KIRKLEES METROPOLITAN COUNCIL INVESTMENT & REGENERATION SERVICE

DELEGATED DECISION TO DETERMINE APPLICATIONS FOR CONSENT, AGREEMENT OR APPROVAL REQUIRED BY CONDITION

Reference No:	2024/44/93400/E
Site Address:	Land off, Staincliffe Road, Dewsbury Moor, Dewsbury, WF13 4RD
Description:	Discharge of details reserved by conditions 8 (lighting), 9 (boundary treatment), 10 (arboricultural method statement) on previous permission 2023/93059 for erection of light industrial units
Recommending Officer:	Nina Sayers

DECISION – DISCHARGE OF CONDITION SPLIT DECISION

Tree Protection Plan to BS5837:2012 at:
Staincliffe Road, Dewsbury

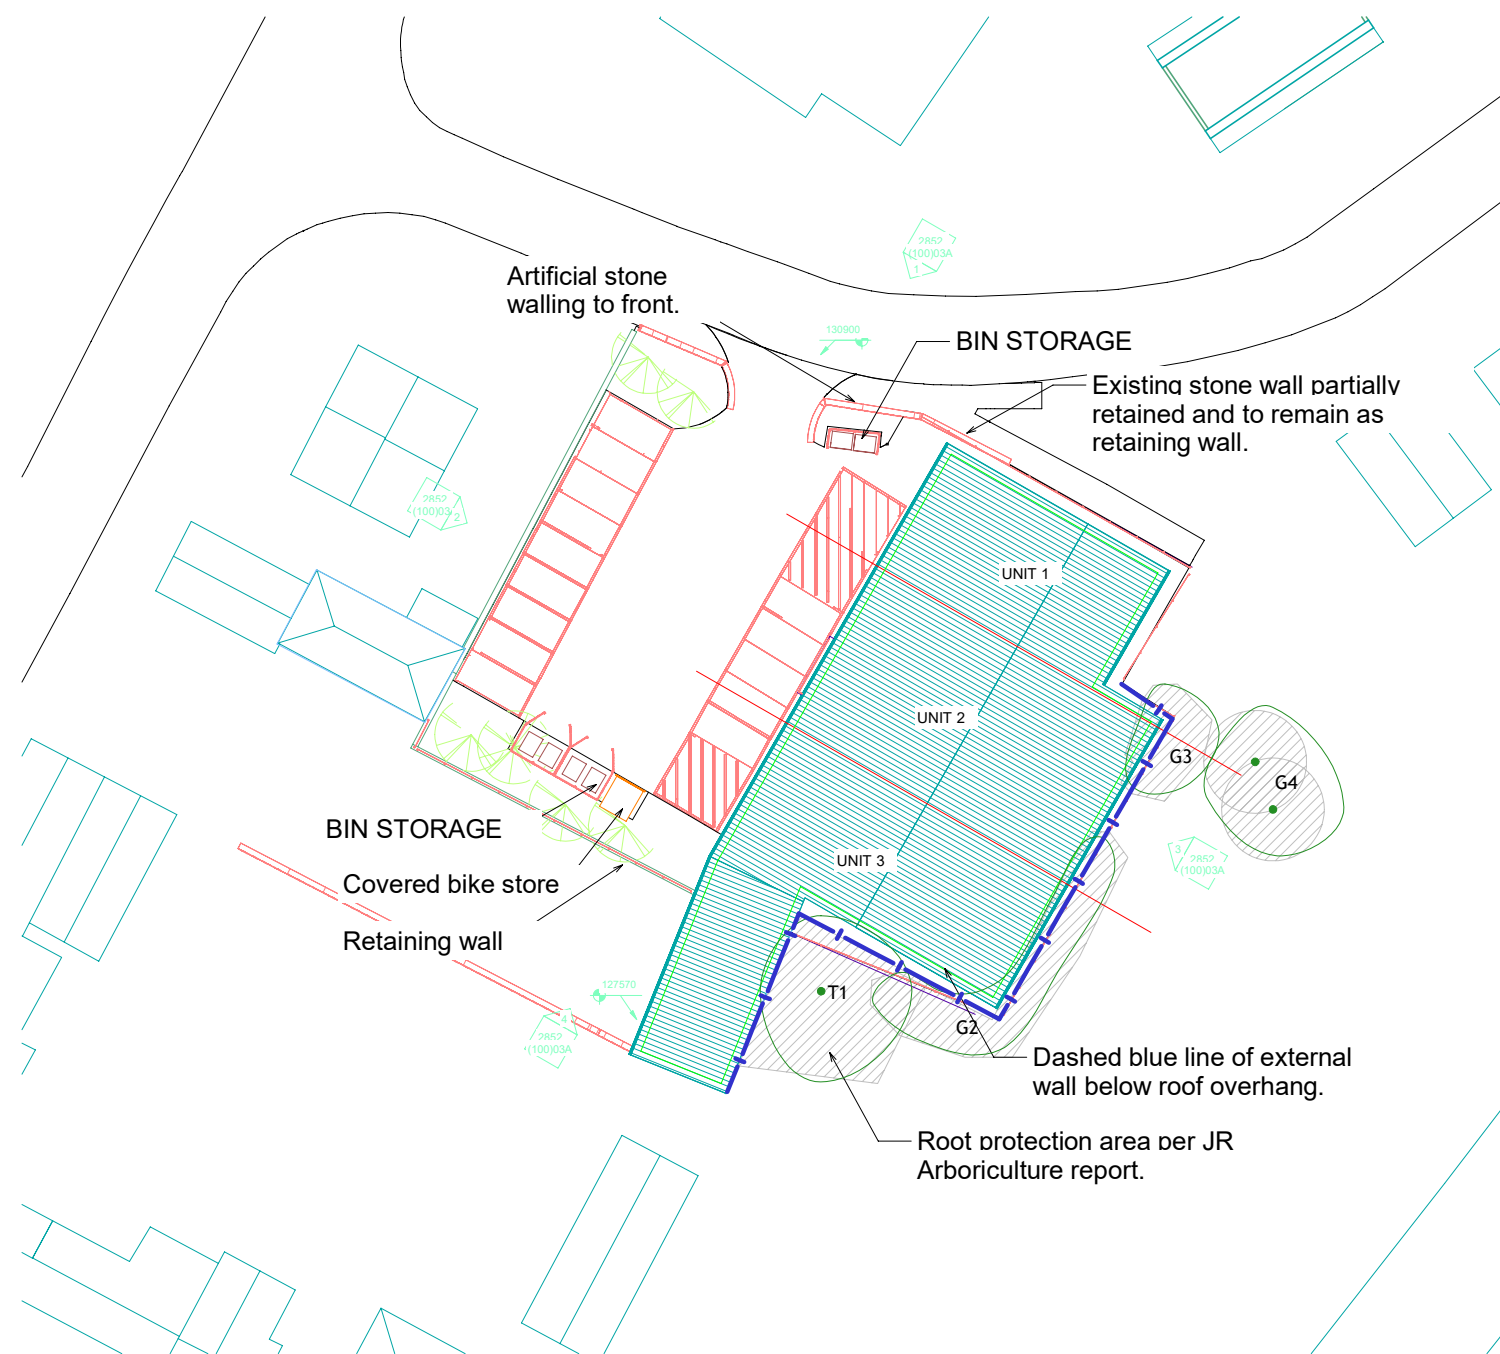
The submitted information has been reviewed by KC Trees. It is considered that the submitted AMS sufficiently details the pruning and protection measures that will be taken during construction. Officers can therefore support the discharge of condition 10.

The submitted Arboricultural Method Statement Ref: '231213 MS' and Tree Survey Ref: '231213' sufficiently details the pruning and protection measures that will be taken during construction. This condition is therefore discharged. It is a requirement of this condition that the development be carried out in accordance with the approved details.
